**Sent:** 21 October 2013 16:46  
**To:** Planning  
**Subject:** Planning application S6/2013/1915/FP - TESCO EXPRESS 59 Station Road

**Location**  
TESCO EXPRESS 59 Station Road  
Cuffley  
EN6 4HX

**Proposal**  
Installation of ATM pod and erection of 15x security bollards

**Amendment**  
New Documents added: Document: EXISTING EAST SIDE ELEVATION - DRG NO. 106 REV A - AMENDED 04-10-13.pdf Document: PROPOSED ATM AND BOLLARDS PLAN - DRG NO 111 REV B - AMENDED 04-10-13.pdf Document: PROPOSED ATM AND BOLLARDS PLAN - DRG NO 112 REV A - AMENDED 04-10-13.pdf Document: PROPOSED ATM AND BOLLARDS FRONT ELEVATION - DRG NO. 113 REV A - AMENDED 04-10-13.pdf Document: PROPOSED ATM AND BOLLARDS SIDE ELEVATION - DRG NO. 114 REV A - AMENDED 04-10-13.pdf Document: SITE PLAN - DRG NO. 100 REV A - AMENDED 04-10-13.pdf Document: EXISTING FRONT ELEVATION - DRG NO. 103 REV A - AMENDED 04-10-13.pdf Document: EXISTING WEST SIDE ELEVATION - DRG NO. 104 REV A - AMENDED 04-10-13.pdf Document: EXISTING REAR ELEVATION - DRG NO. 105 REV A - AMENDED 04-10-13.pdf

Figure 1 – Proposed External Works

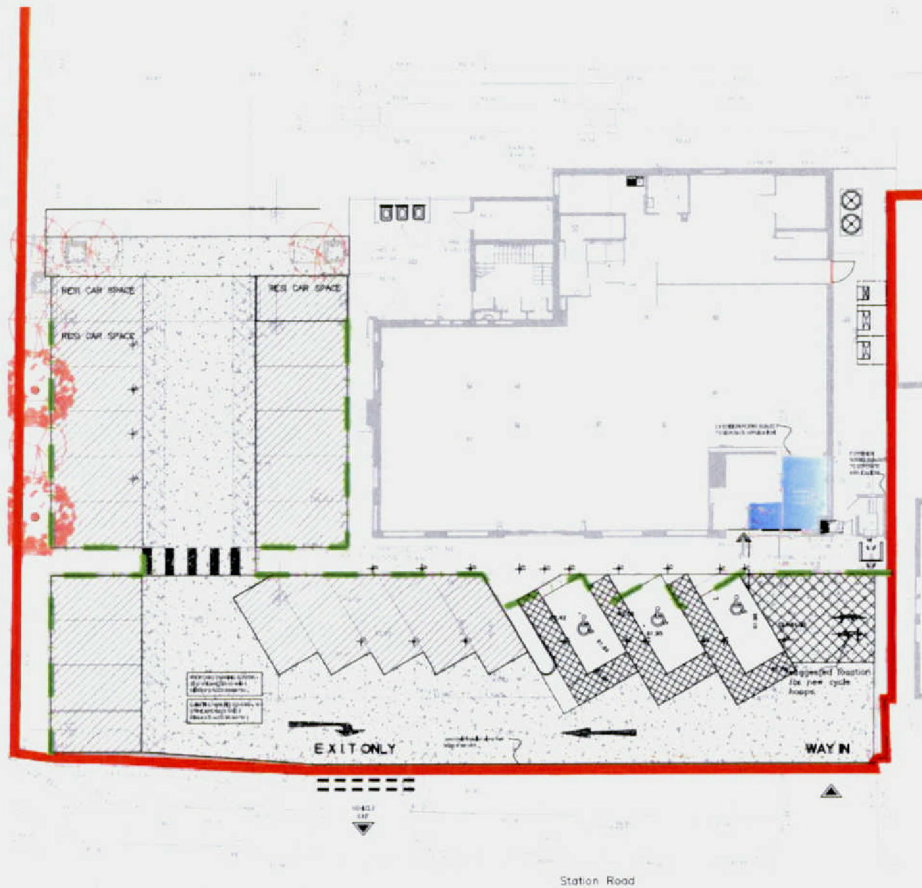
The amended drawing F9D12-161A(00)111 rev B shows 2 new bollards only in front of the ATM and therefore addresses the earlier concerns of the Highway Authority regarding bollard locations. The bike racks appear to have been relocated to the western side of the building, which leaves the delivery bay free for delivery vehicles. Hertfordshire County Council as Highway Authority considers that the details provided on this amended plan overcome the earlier concerns. Although not a matter for the Highway Authority I note that the bike rack locations will reduce width of the pedestrian access to the rear of the site and the LPA may have a view on this.
